CITY OF ALBUQUERQUE

Re: Sts. Peter & Paul Church School, 5800 Ouray Rd NW
Request for Certificate of Occupancy- Transportation Development
Architect's Stamp dated 07-08-15 (H11-D062)
Certification dated 01-17-17

**RE: St. Peter and Paul Church, 5800 Ouray Road NW
Grading and Drainage Plan
Engineer's Stamp Date 4-16-2015 (File: H11-D062)**

**RE: St. Peter and Paul Church, 5800 Ouray Road NW
Grading and Drainage Plan
Engineer's Stamp Date 3-20-2015 (File: H11-D062)**

GRADING AND DRAINAGE NARRATIVE

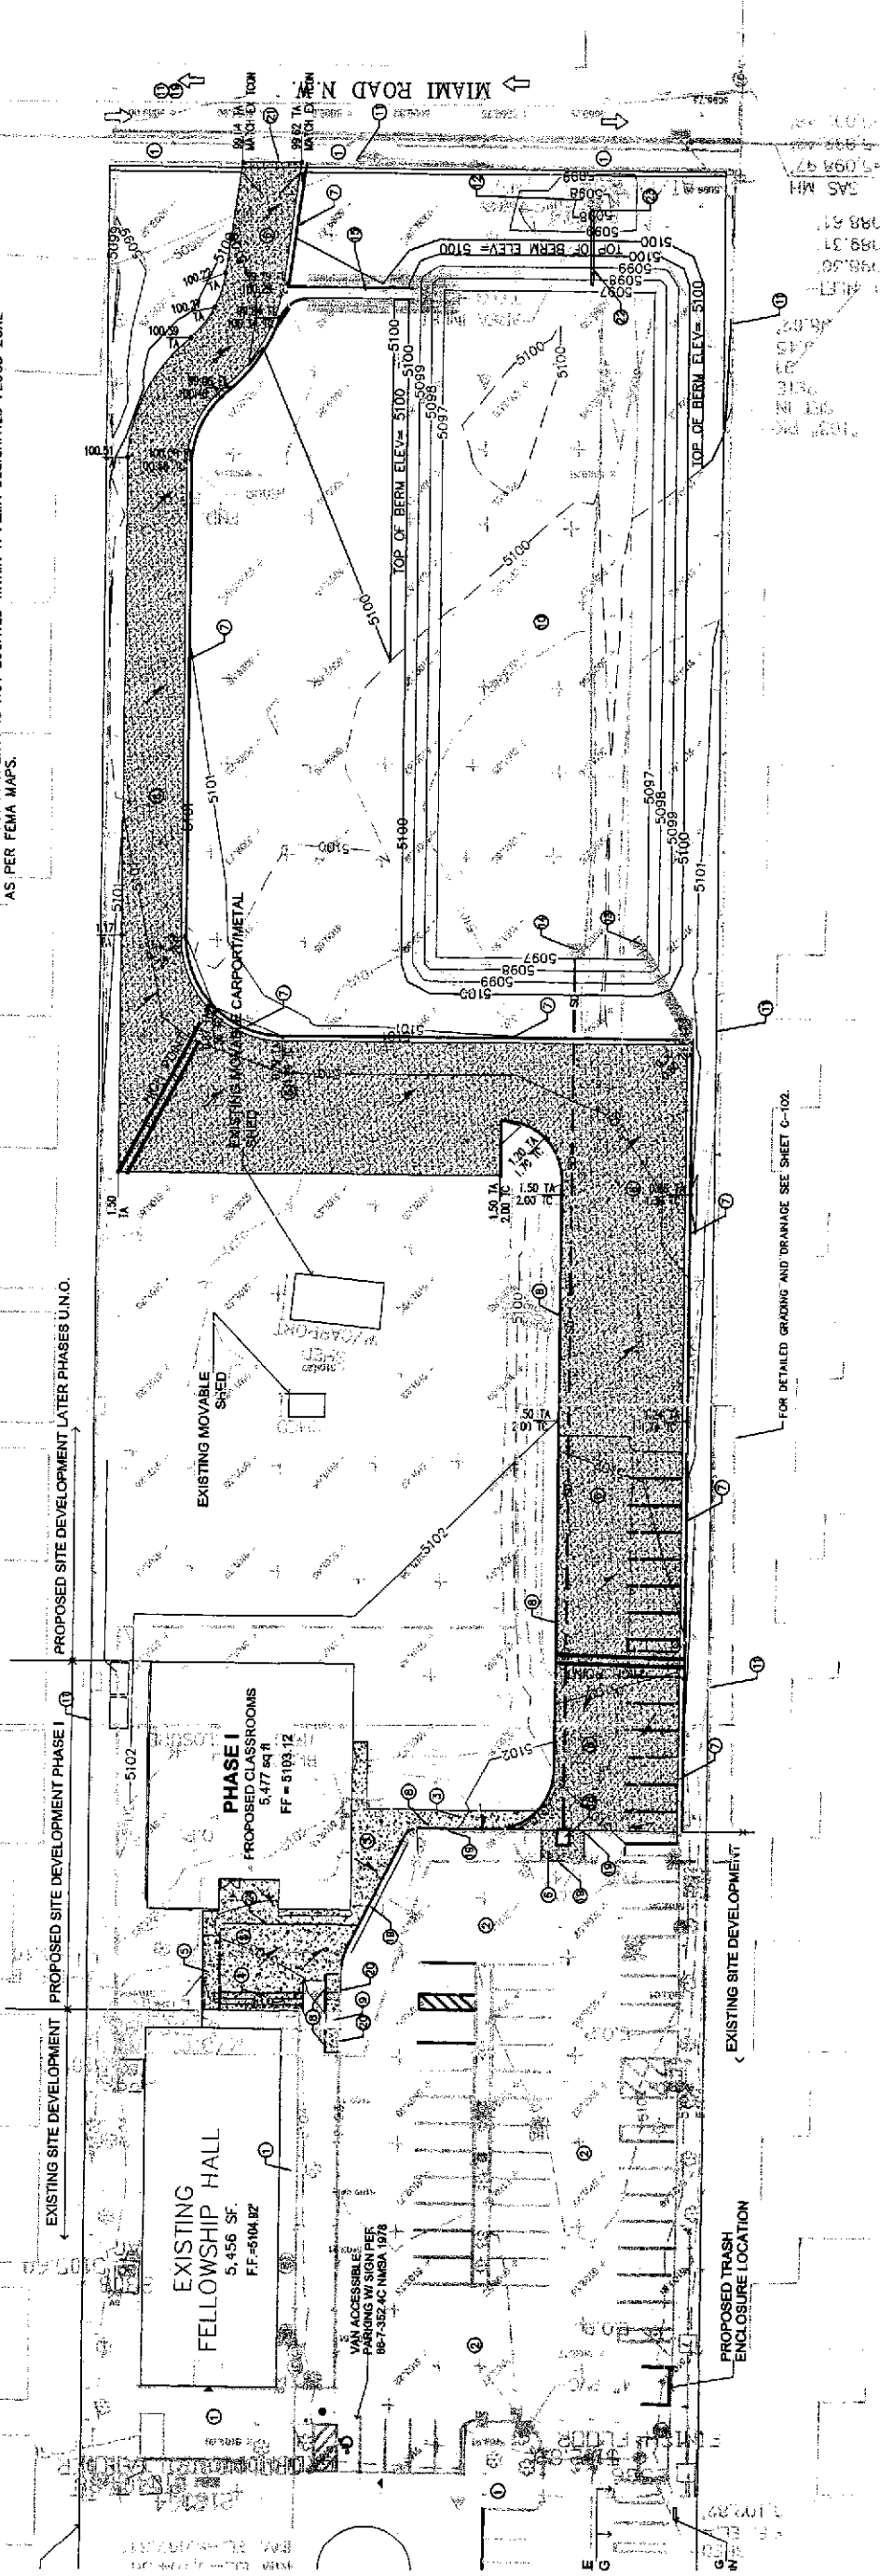
| PO Box 1293 | 1) Highlight site on vicinity map, and show Basin A-1 and B-1 boundaries. In the Drainage Narrative, explain Basin A-1's ultimate discharge to the southwest corner of the property if this is the case. |
| Albuquerque | 2) In discussion of off-site flows, also mention any impact of on-site drainage to the property to the west and east or lack there-of. Provide more existing spot elevations along the western and eastern boundaries of the site. |

1. Highlight site on vicinity map, and show Basin A-1 and B-1 boundaries. In the Drainage Narrative, explain Basin A-1's ultimate discharge to the southwest corner of the property if this is the case.
Please see sheet c-100 for highlighted vicinity map. Please see sheet C-101 for the drainage basin boundaries. Please see c-100 under the conclusion for the description of Basin A-1 ultimate discharge to SW corner of property.

2. In discussion of off-site flows, also mention any impact of on-site drainage to the property to the west and east or lack there-of. Provide more existing spot elevations along the western and eastern boundaries of the site.
Please see c-100 under the off-site flows for impact of onsite flows to offsite properties. Please see c-101 for additional existing spot elevations.

C-101

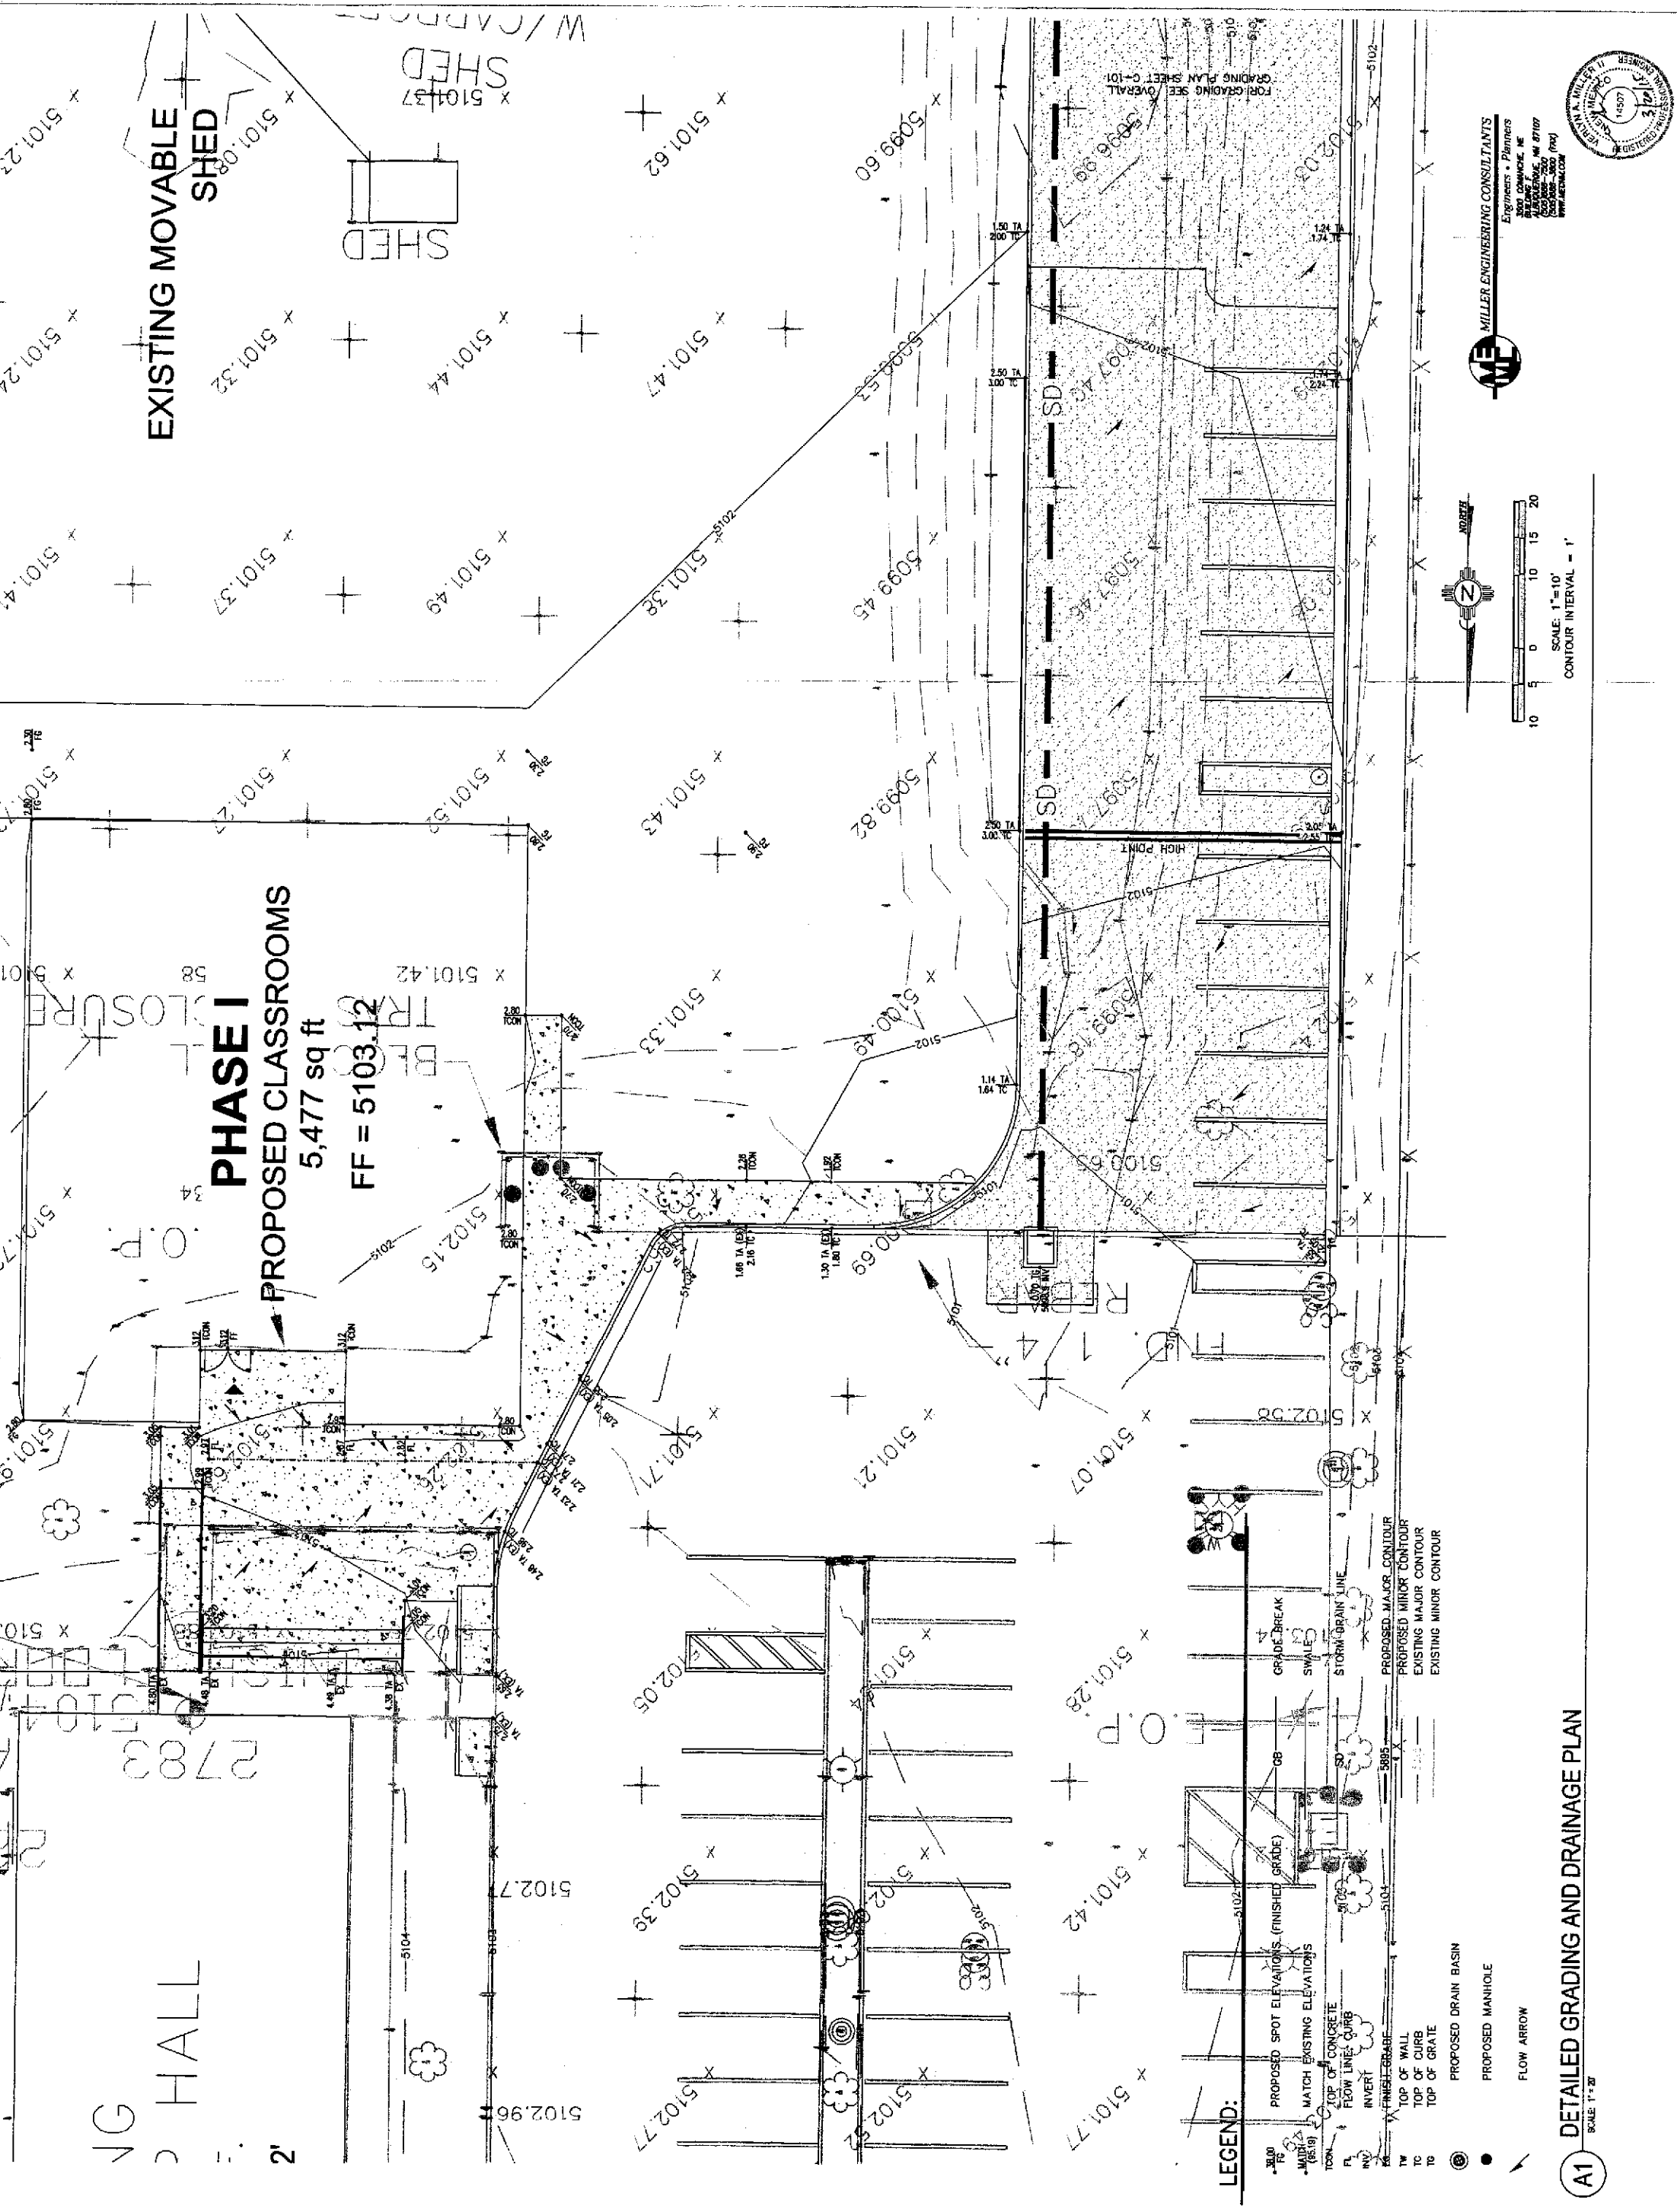
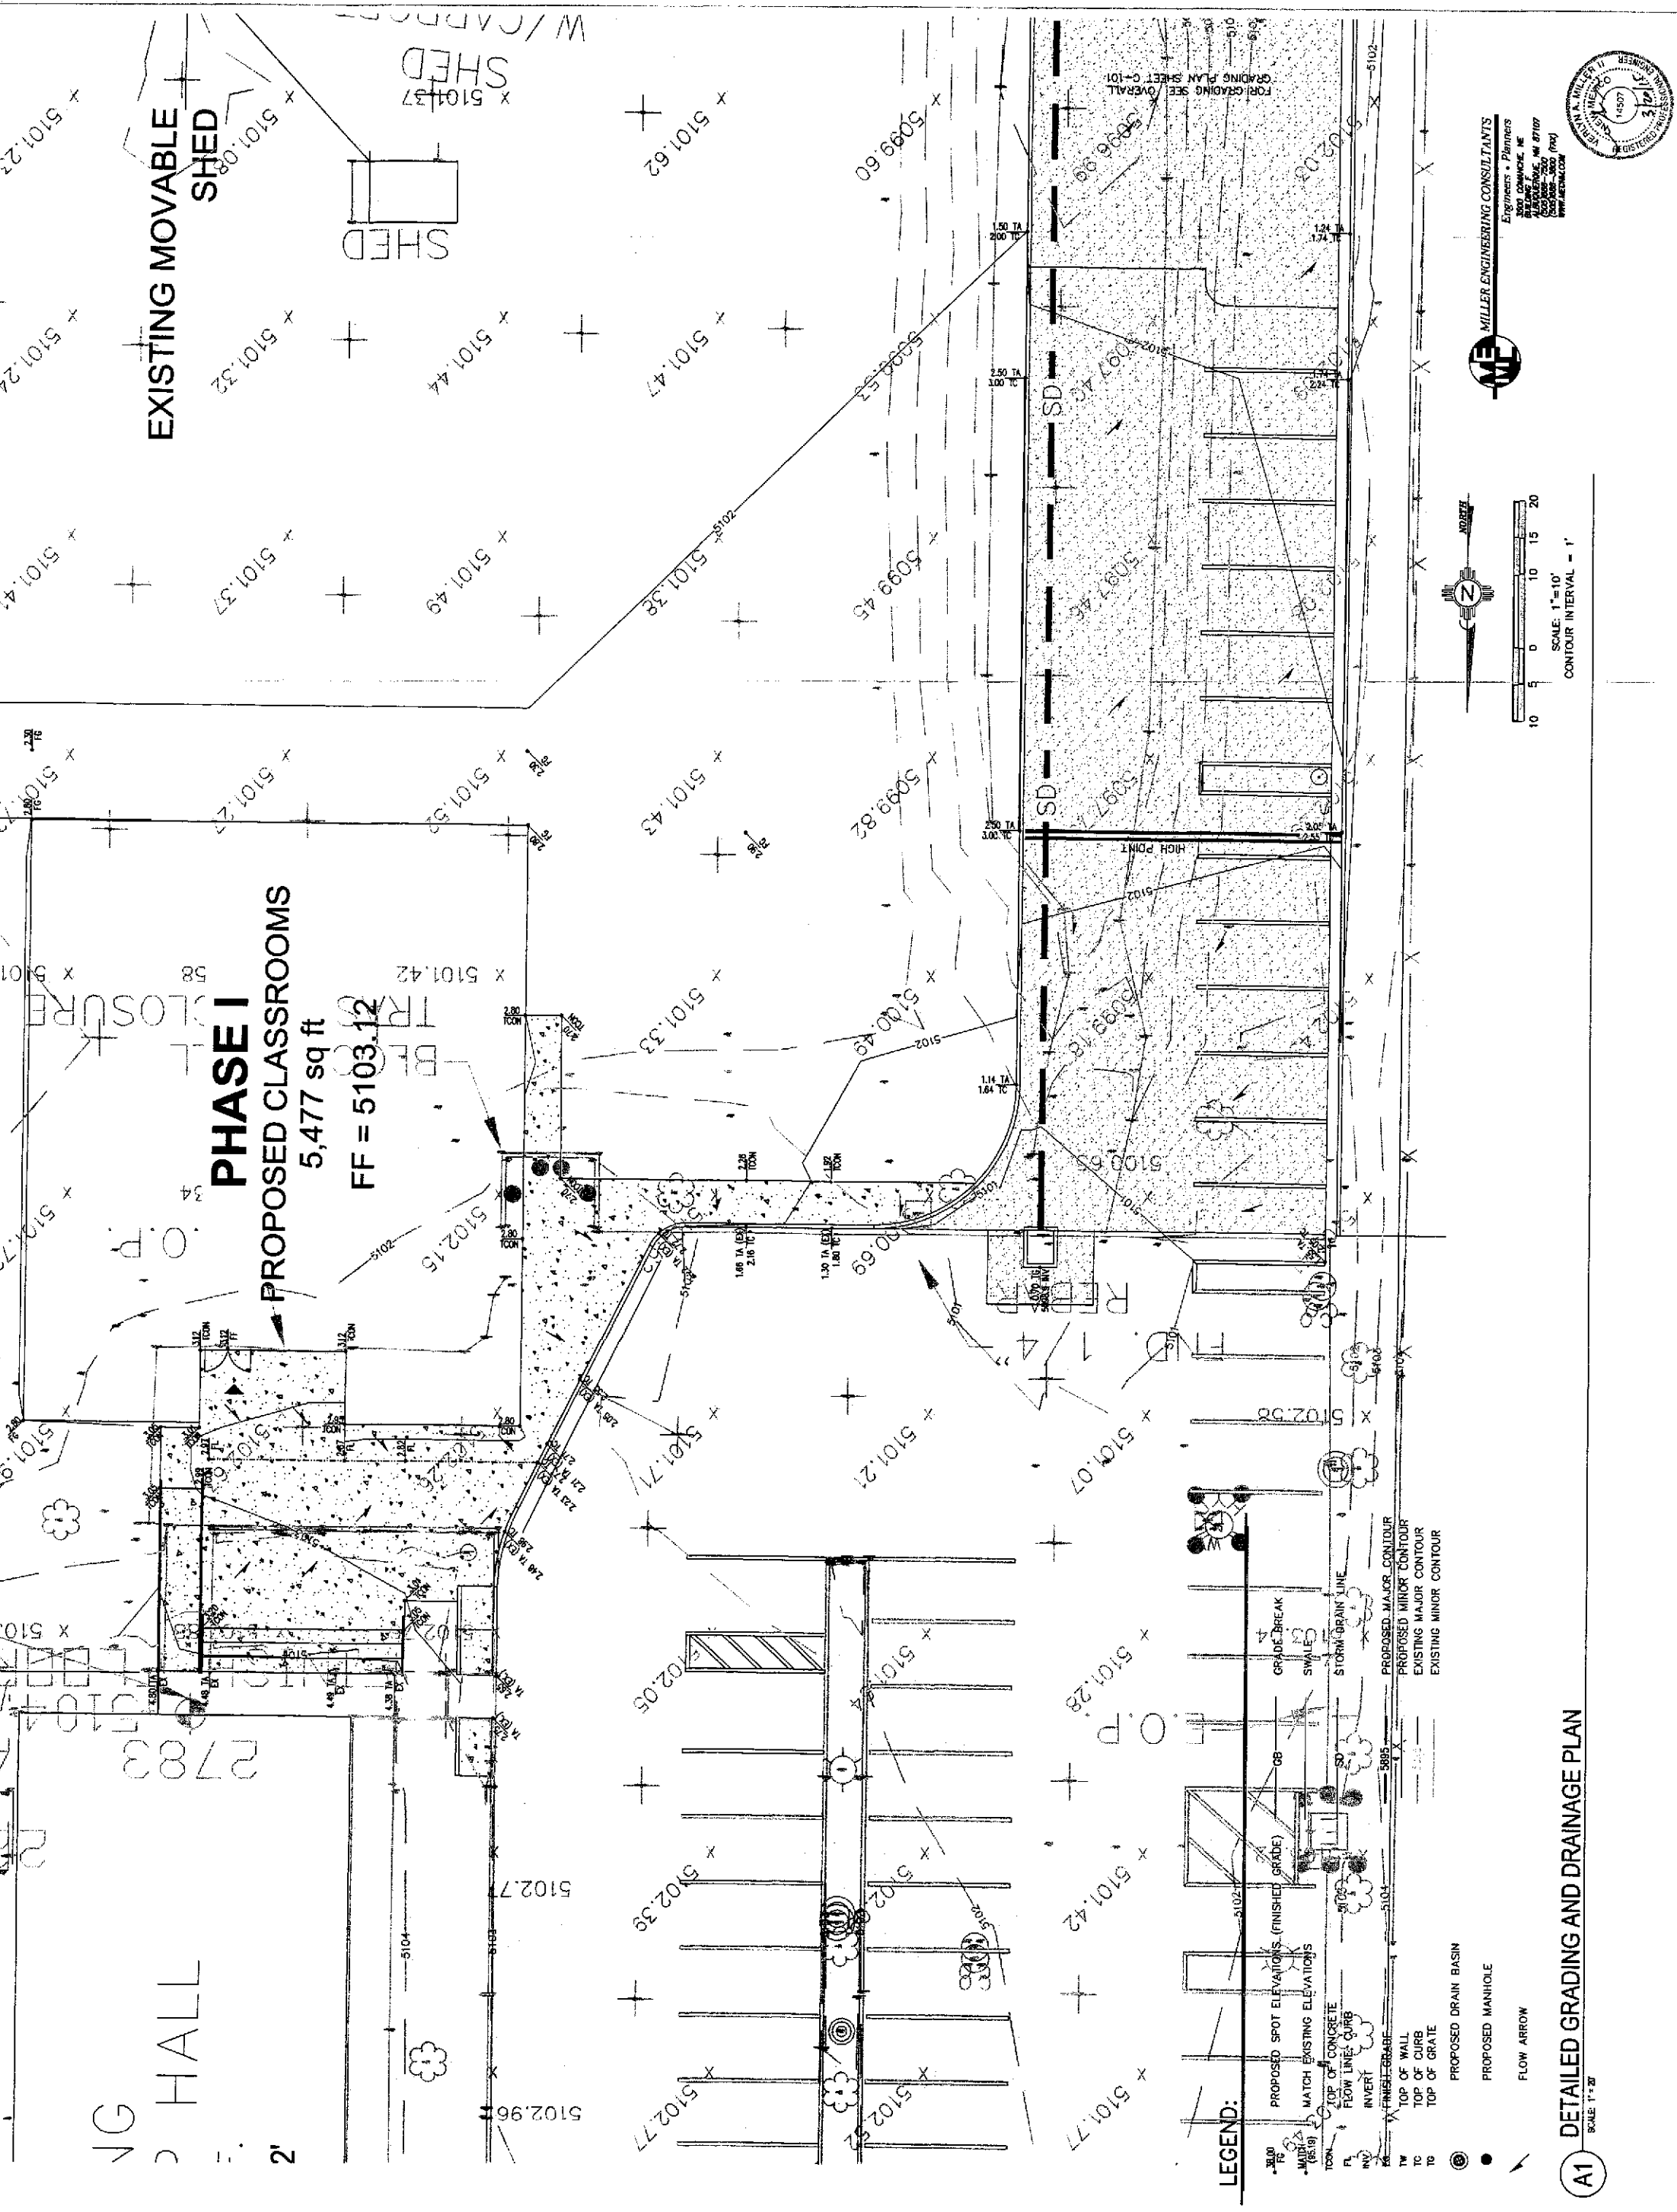
| New Mexico 87103 | 3) For the new 12" pipe tie-in to the existing inlet at the southwest corner of the site, provide a downstream invert elevation, and show the invert elevation of this existing inlet to ensure positive flow to the storm drain in Miami Road. Show and label existing storm drain in Miami Road and the tie to the existing storm drain in Miami Road. |
| www.cabq.gov | 4) Label curb cuts where needed in low spots within the newly paved areas. It looks like a curb cut needs to be called out where Keyed Note 13 calls out a riprap rundown from the parking lot. |

- 1) Keyed Note 17 for the storm drain is not called out on the plan view.
- 2) Is the top of grate elevation meant to be called out as 5100.70 on Keyed Note 16? If so, call it out, and double-check on pipe cover since with the listed pipe invert elevation, it appears that the pipe cover is less than a foot.
- 3) Show capacities, discharge flows, and pipe slopes for all proposed on-site storm drain pipes. Show capacity of new on-site inlet. For any proposed curb cuts, also provide capacity calculations.
- 4) For the proposed pond, label complete pond volume and WSEL Elevation.

Please see Sheet C-101 for the curb cut call out.

Please see Sheet C-101 for the key note call out.

Please see Sheet C-101 and C-102 for revised elevations.

Please see Sheet C-101 for additional pond information.
